CITY OF ALBUQUERQUE

**Re: Leyba Body Shop, Lot 16A/Block 3, Mesa Verde Addition, 103 Tennessee NE
Grading and Drainage Plan
Engineer's Stamp dated 12-02-12 (K19/D146)**

Based upon the information provided in your submittal received 12-04-12, the above referenced report can not be approved for building permit until the following comments are addressed:

GRADING PLAN

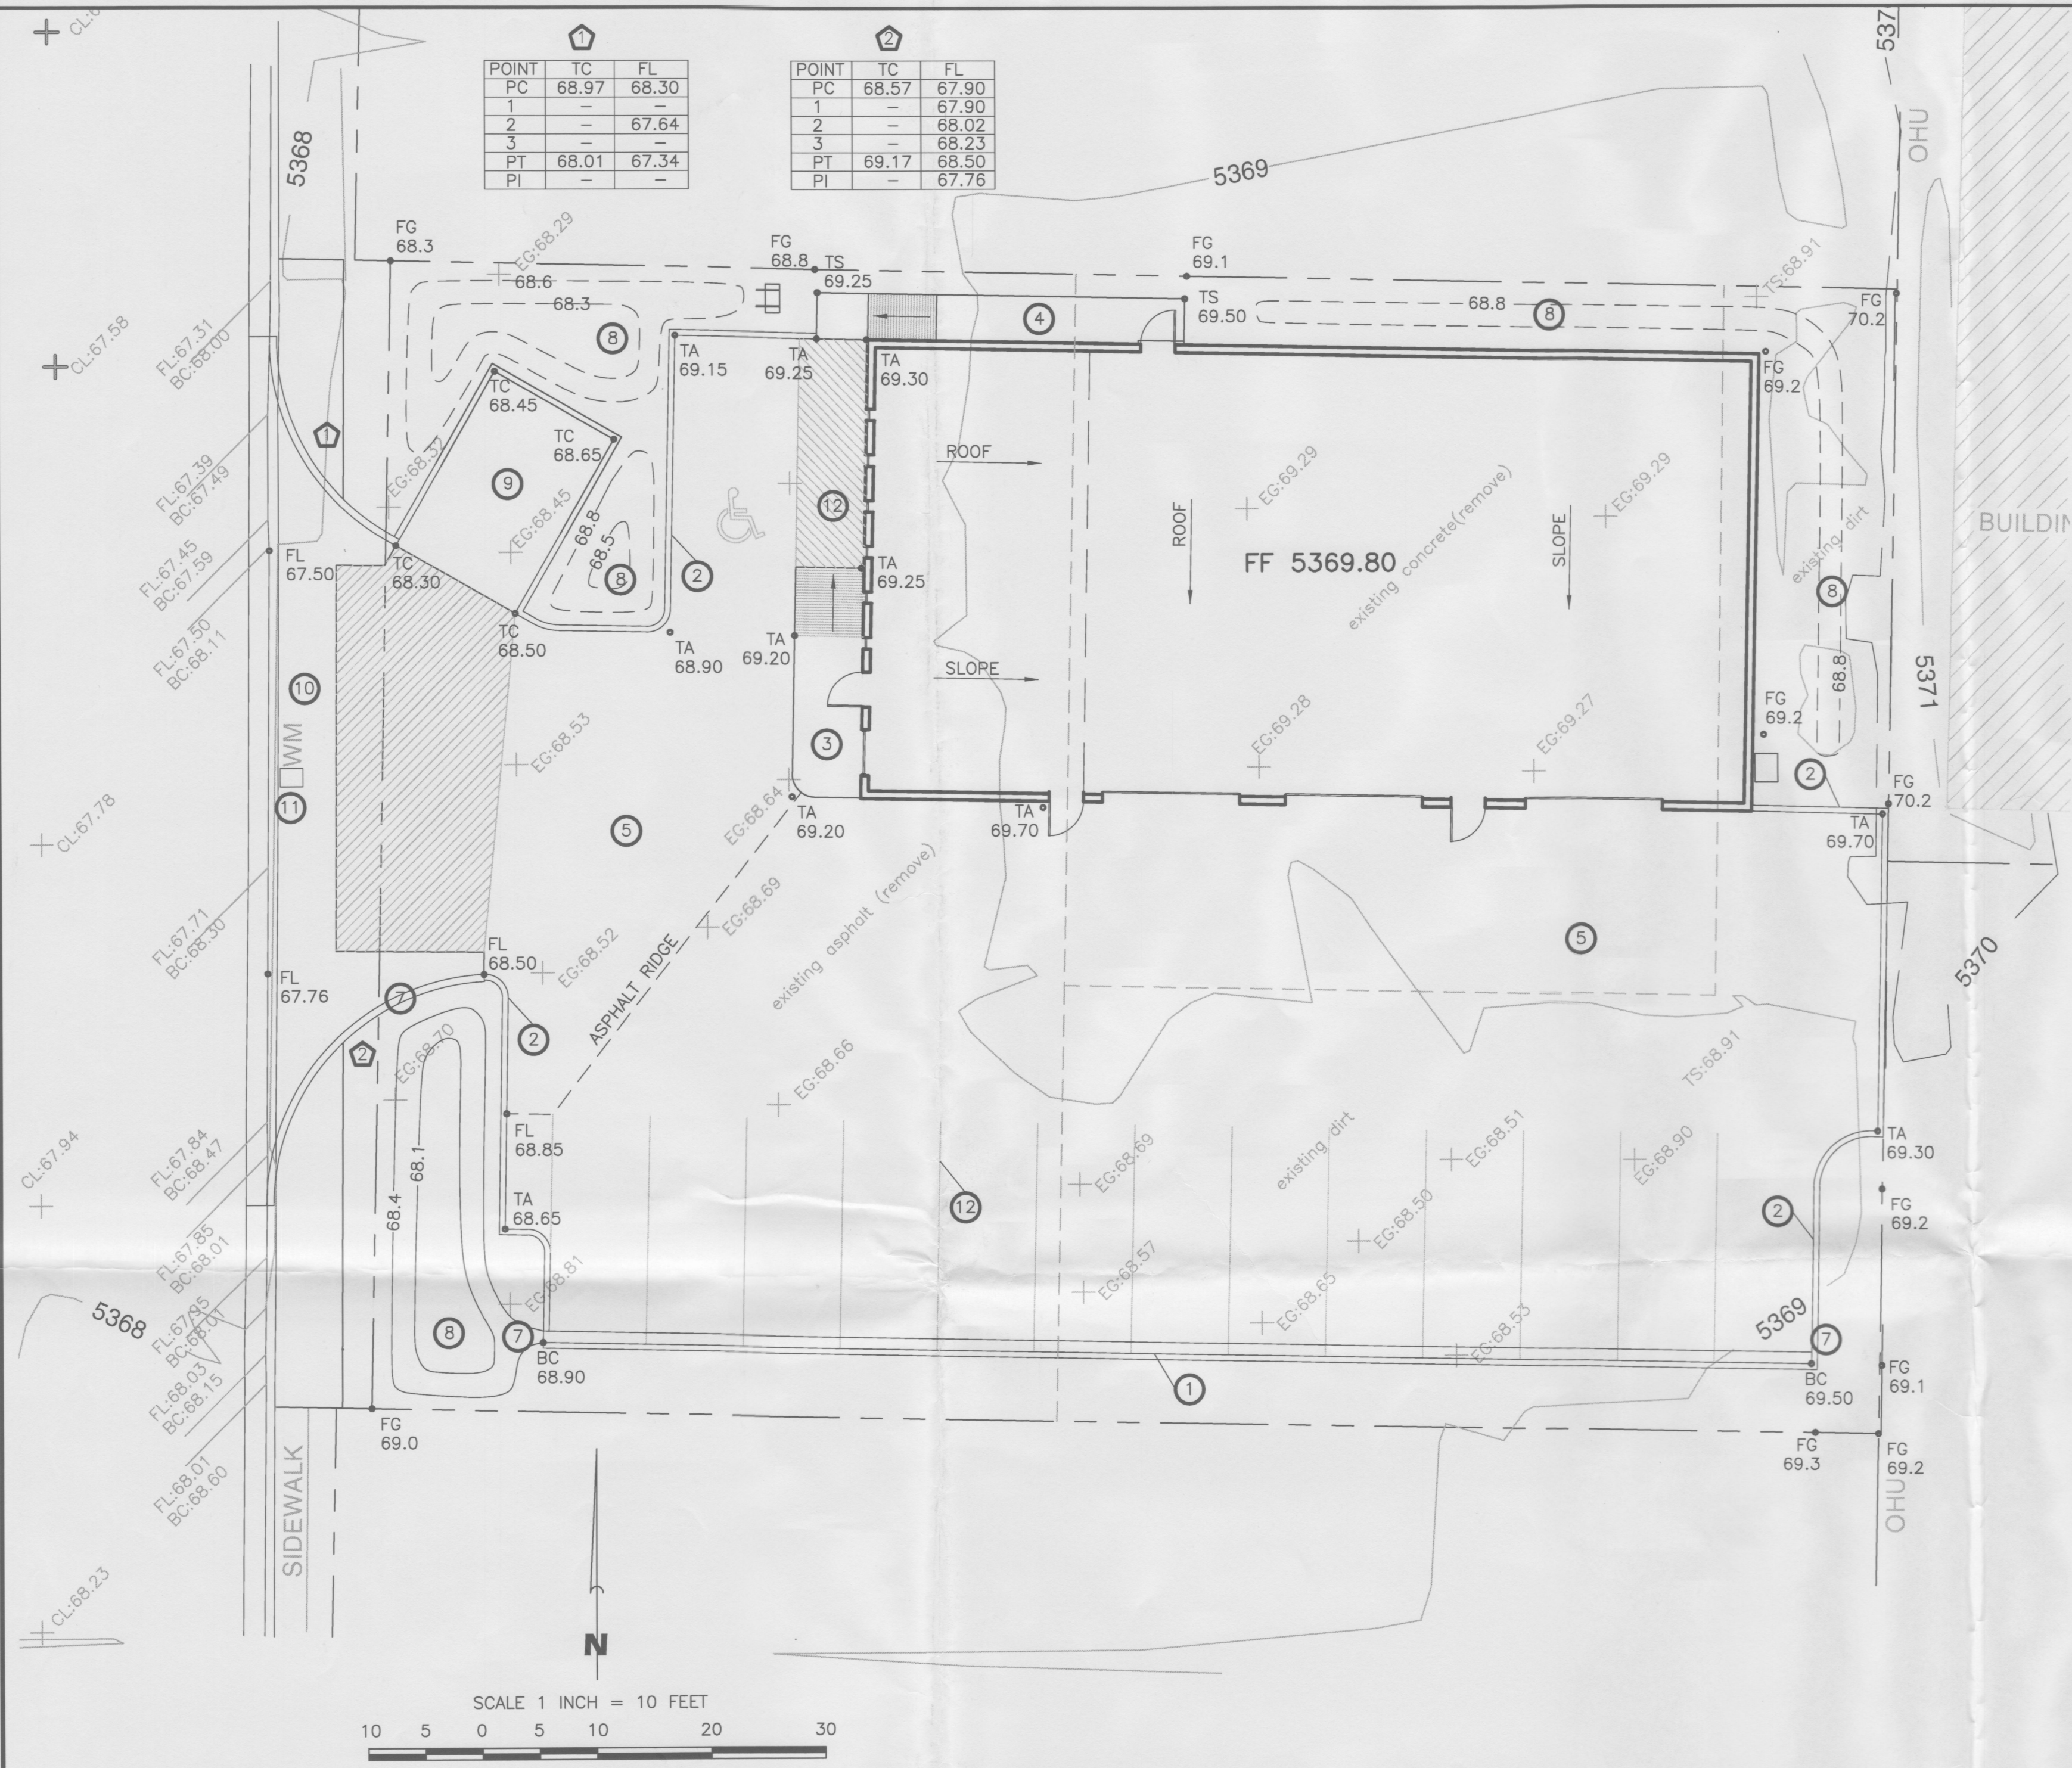
- How are the flows from the east lot being accepted? It appears that the curbing is blocking the flows from entering your site.
- Remove note 10 where it is placed in odd places.
- Place spot elevations around the perimeter of the site.
- What type of treatment is being placed behind the Curbing at the south end of the site?
